INTERIOR TENANT FIT-UP FOR:
OFFICE TENANT
SUITE 1 & 2
15 MIDDLE STREET
PORTLAND, MAINE 04101

Jeanie Bourke - RE: 22 Hancock St., BP#2014-02364 (15 Middle)

From: Jeanie Bourke [mailto:JMB@portlandmaine.gov]
Sent: Friday, October 31, 2014 10:47 AM
To: Matt Provencal
Subject: 22 Hancock St., BP#2014-02364 (15 Middle)

1ST FLOOR PLAN

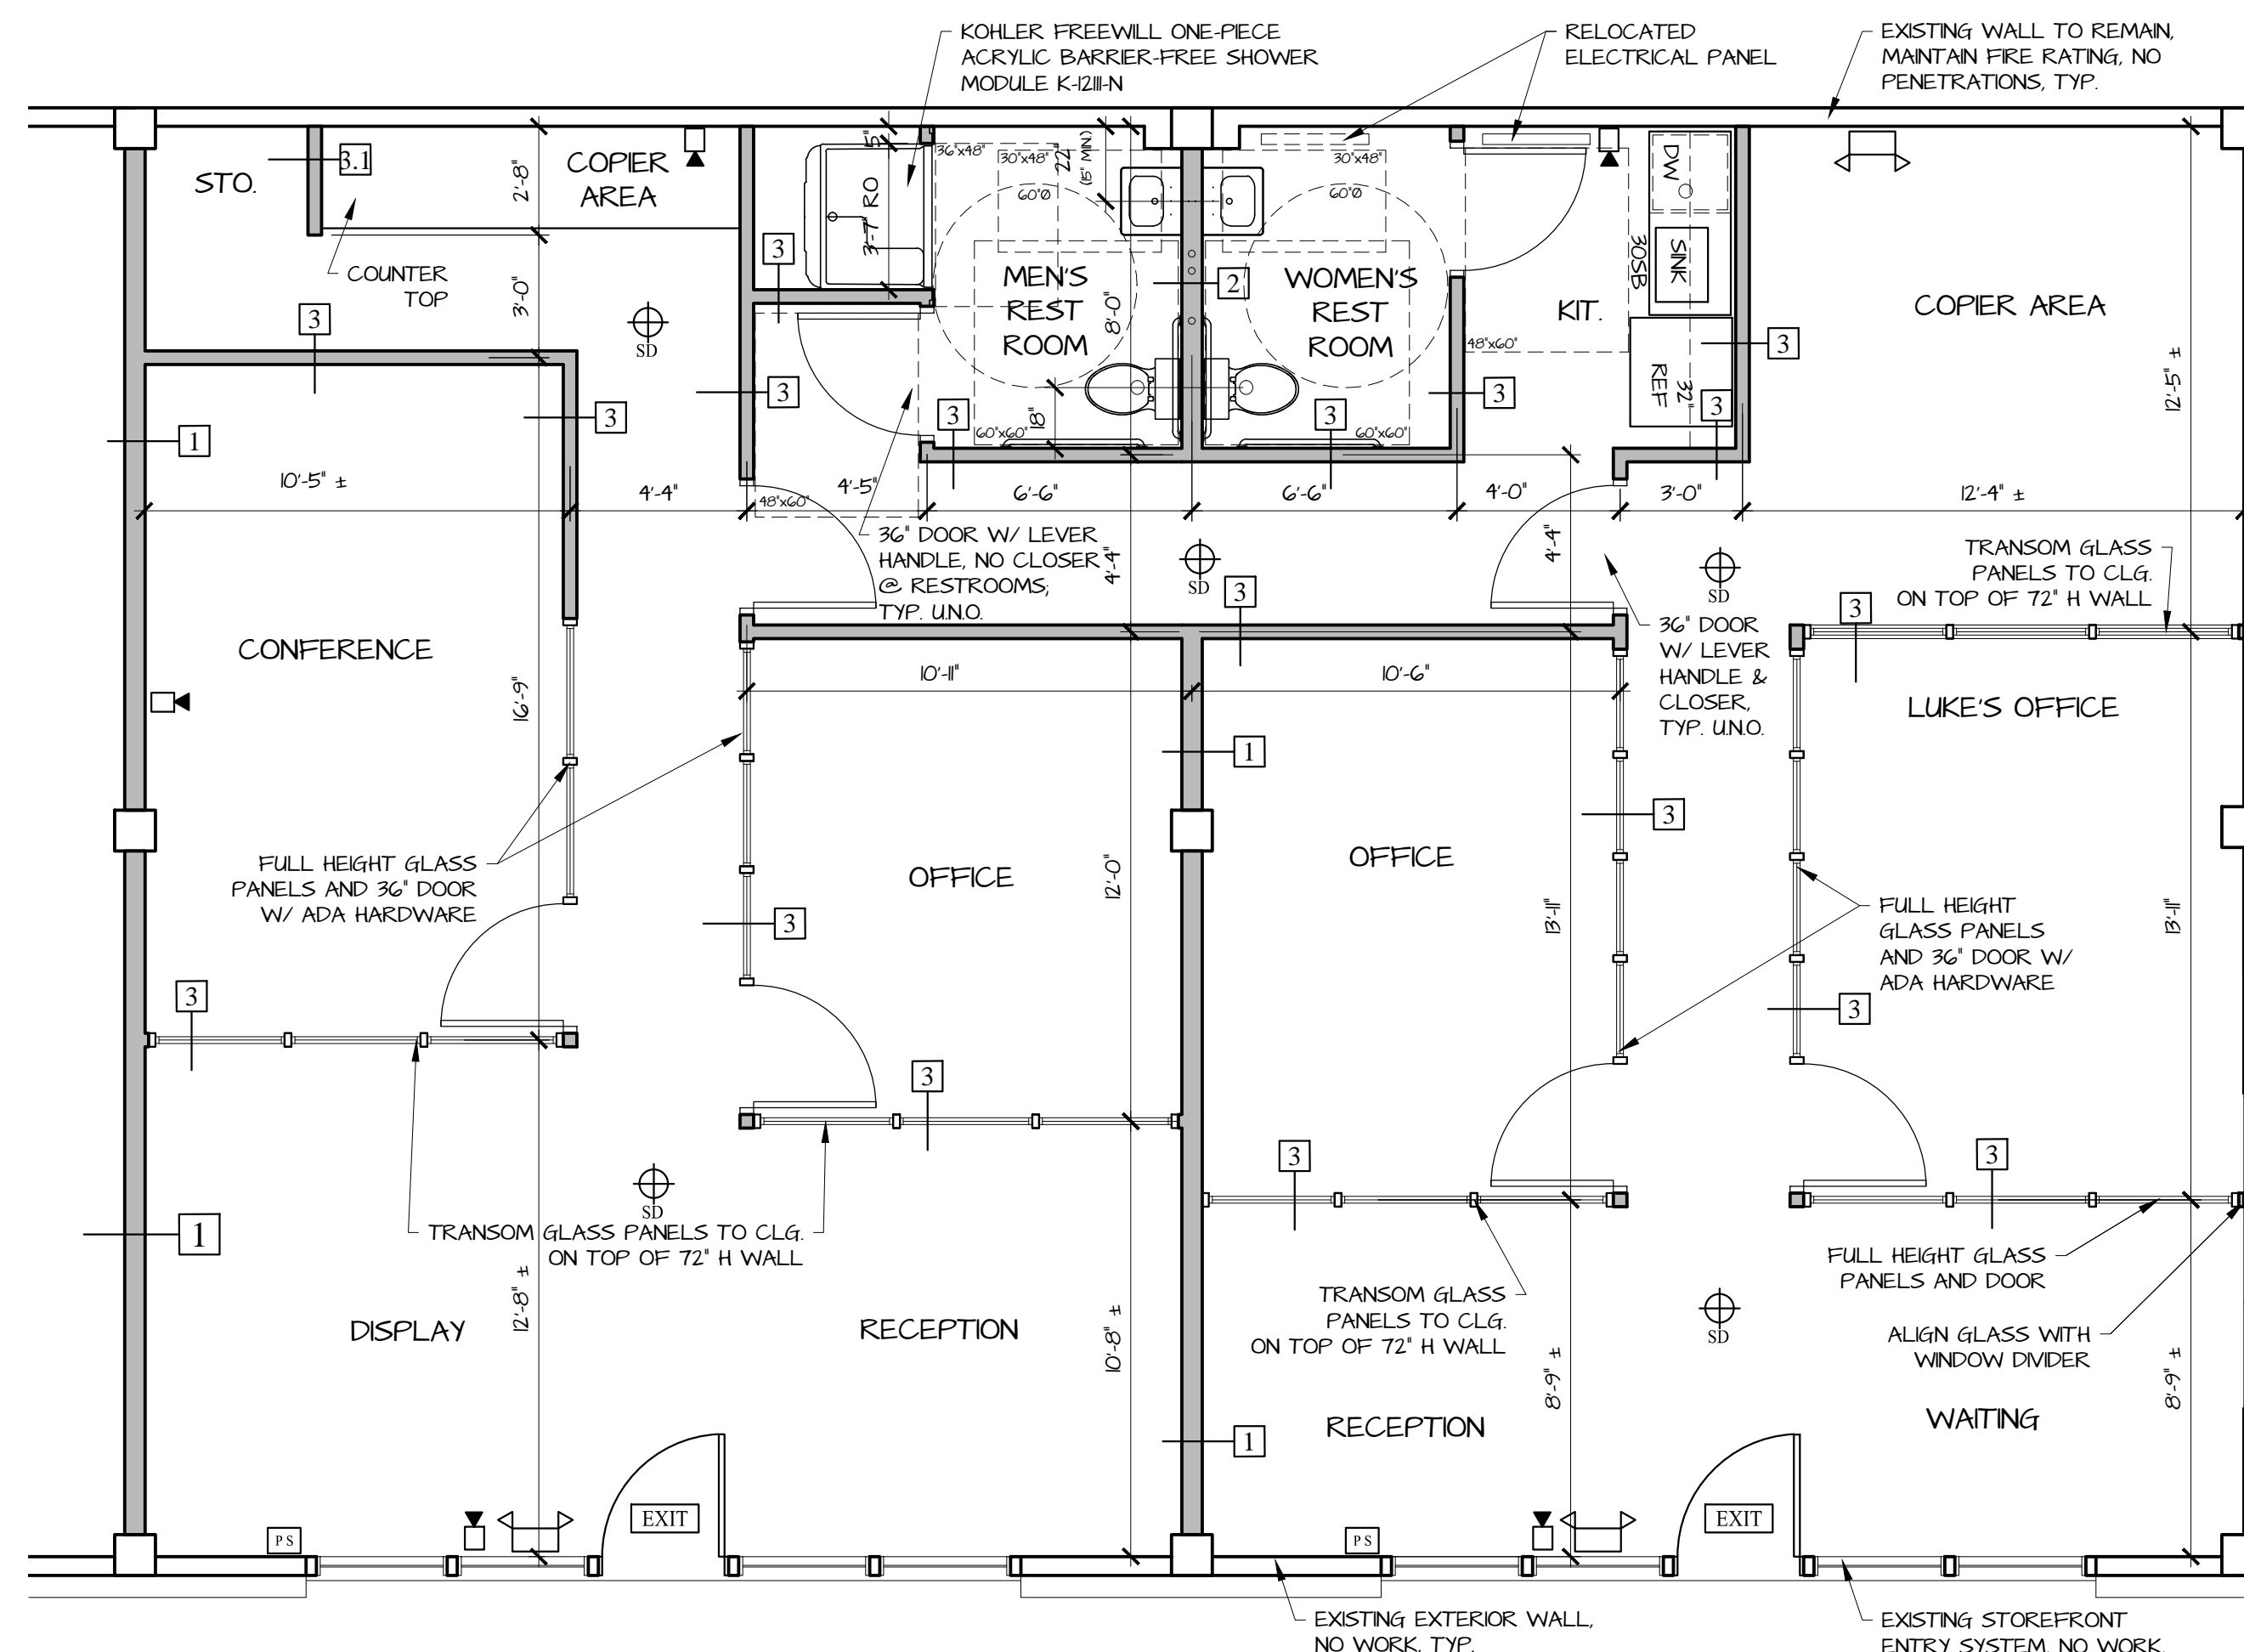
1. The plan does not show any wall demo, was this a vanilla box, or are there existing tenant or condo demising walls? If so, the plan should reflect this, as 2 condos are merging. **There are currently no walls existing at any of the 3 spaces. The condos are staying as two separate entities purchased by one buyer; this would not be a merger. The spaces simply share a kitchenette.**
2. What is the ceiling design? Do you have a RCP, or is it all ACT? **We have not put together a RCP as it will all be suspended acoustical ceiling tiles...design build with lighting and HVAC.**
